City of Albuquerque Stormwater Construction Site Inspection Report

ESC File No.	F16E014C	Project Name:	ABCWUA Customer Service and Operations		
NPDES Id. No.	NMR10027A	Location:	6000 Alexander Blvd. NE		
5/4/2021	Owner	Contractor			
Operator	ABCWUA	Bradbury Stamm			
Contact name & title	Scott Salvas	Eloy Apodaca			
e-mail	ssalvas@abcwua.org	eapodaca@bradburystamm.com			
Contact Phone #	505-230-2344	505-259-8576			
COA Inspector	Thomas Evans	Start/End Time:	3:20 PM/3:45 PM		
Construction Phase:	Stabilization				
Type of Inspection:	☒ Regular	☐ Storm Event	☐ Past Storm Event >0.25"	☐ 311/Complaint	
Weather at time of inspection?		clear	Temperature: ~	74	
Estimated date of last storm 0.25" or greater		5/3/2021

EROSION
CONTROL
PLAN

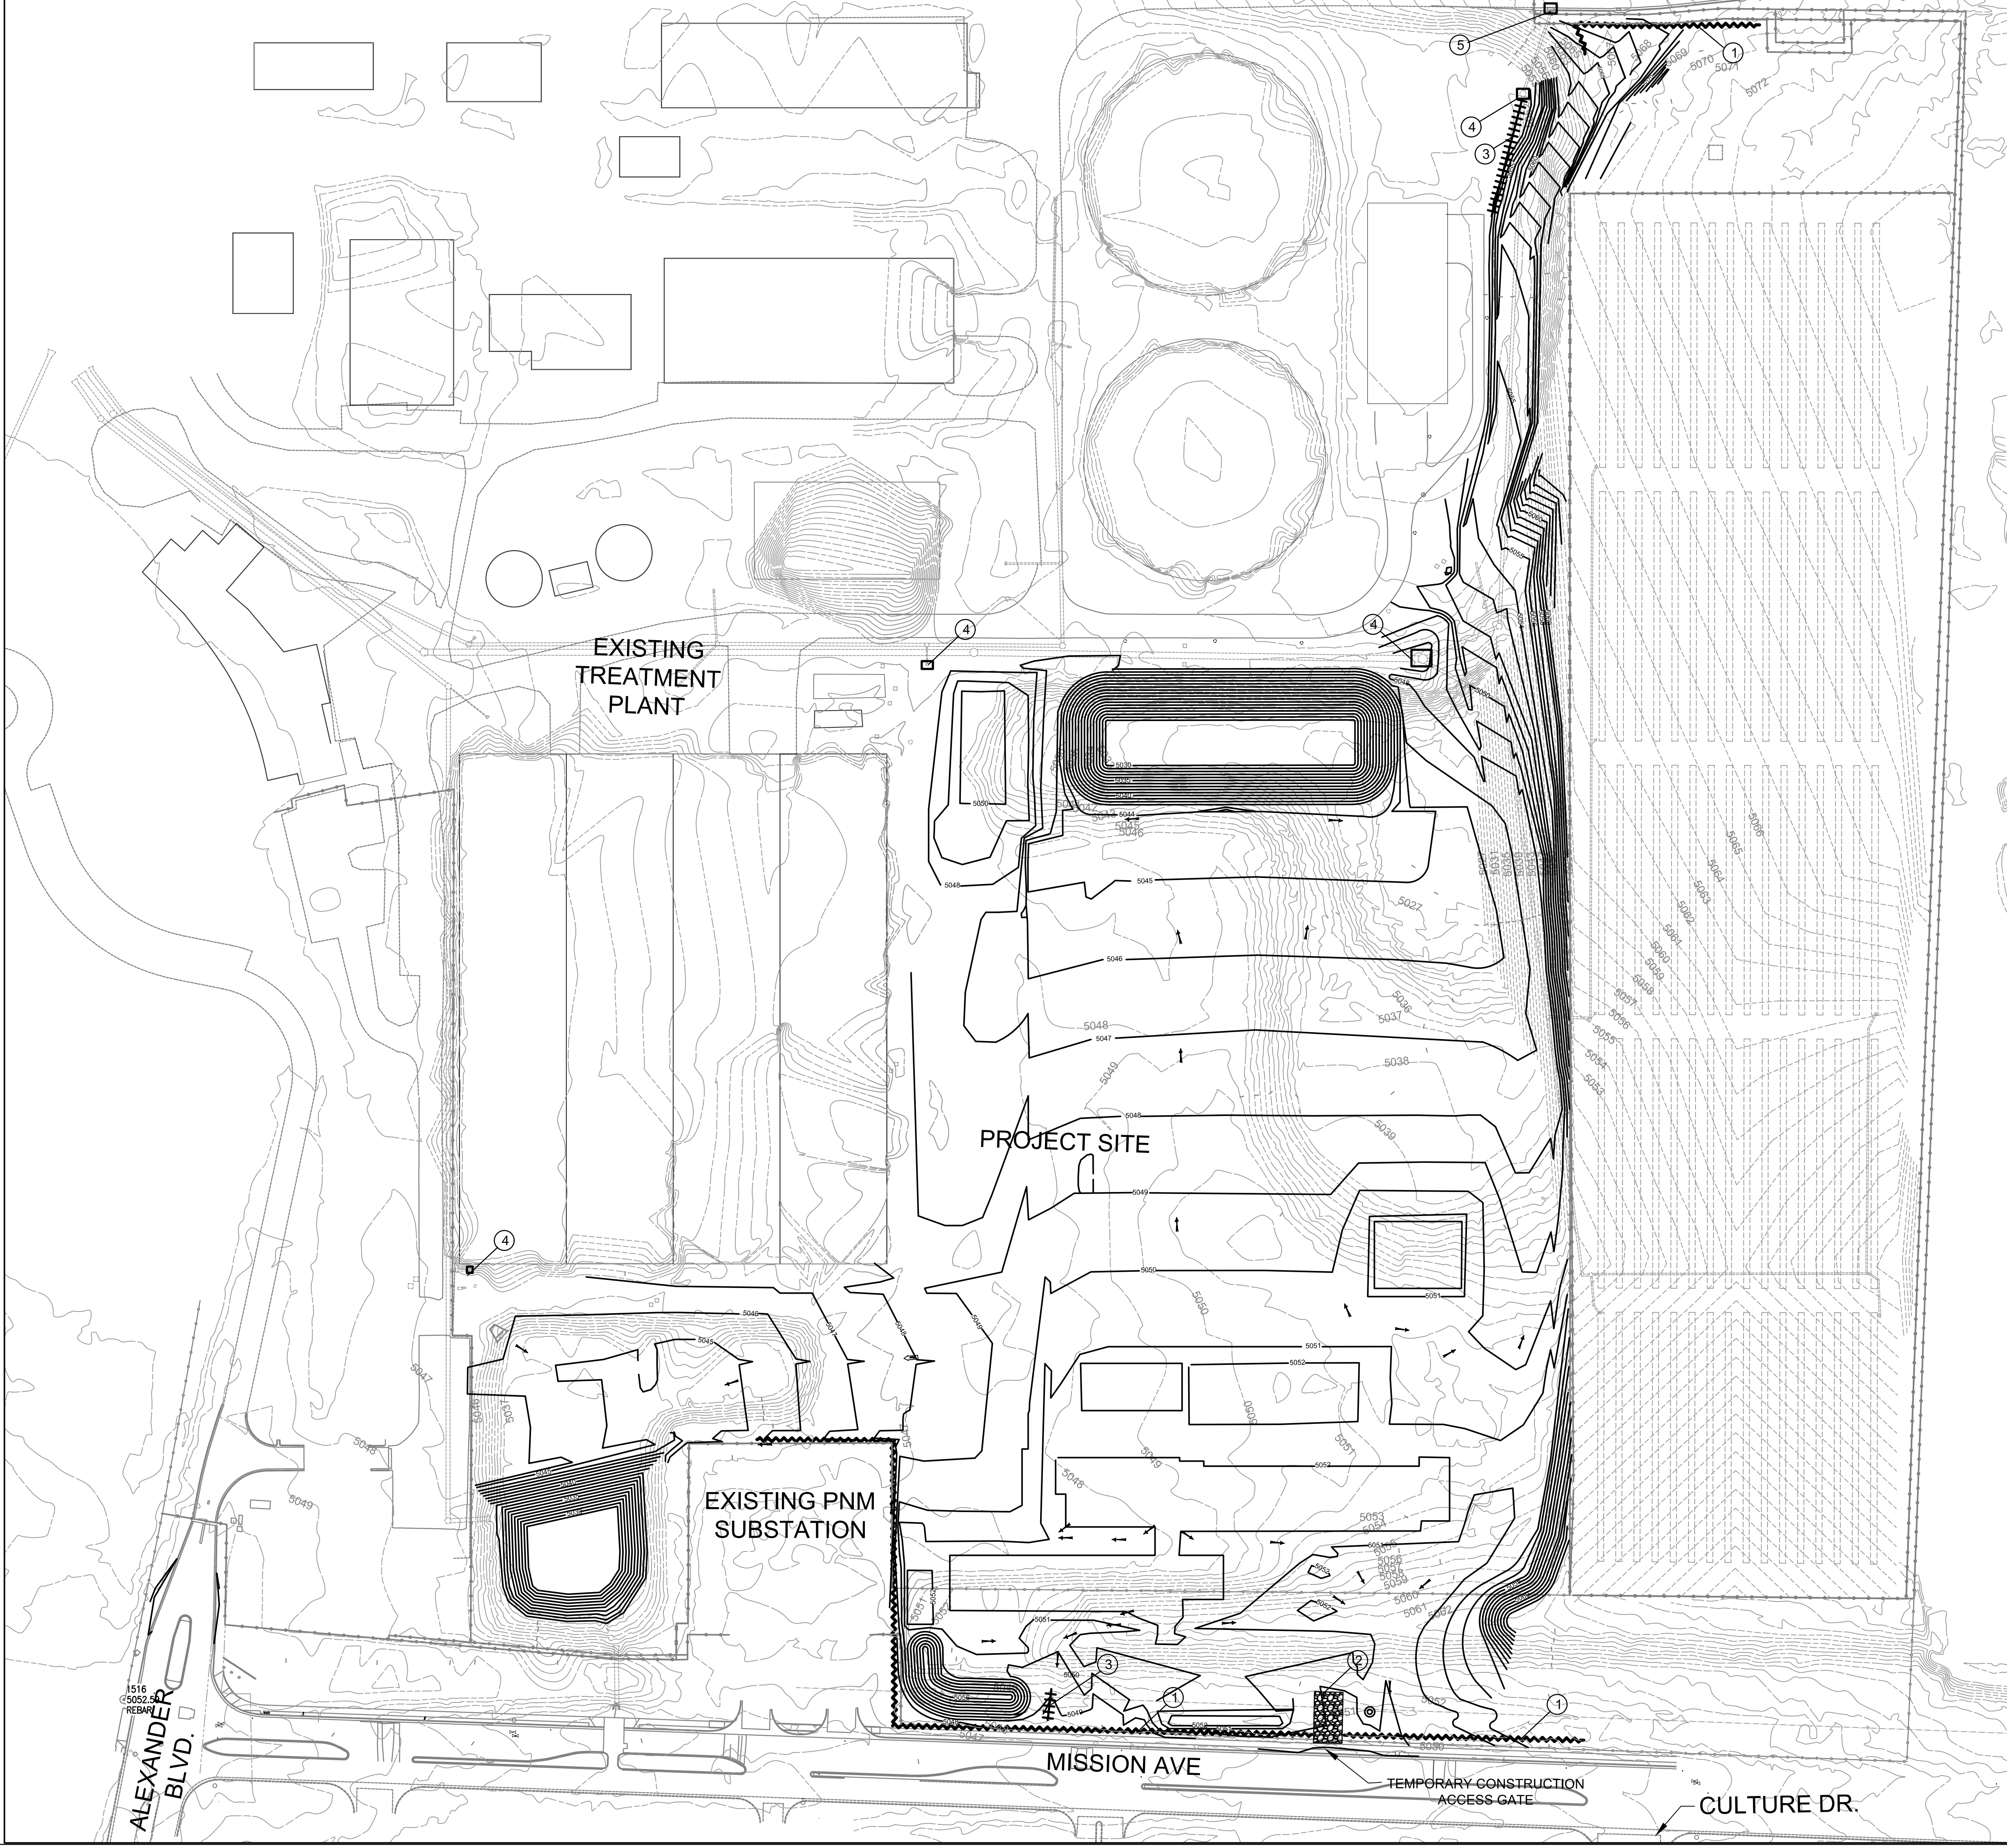
Item Number	Deficiency/ Corrective Action				
1	Disturbed slopes at the pond do not appear to be stabilized. Abide by stabilization requirements set forth in CGP 2.2.14				
2	No posting of permit coverage.				
3					
4					
5
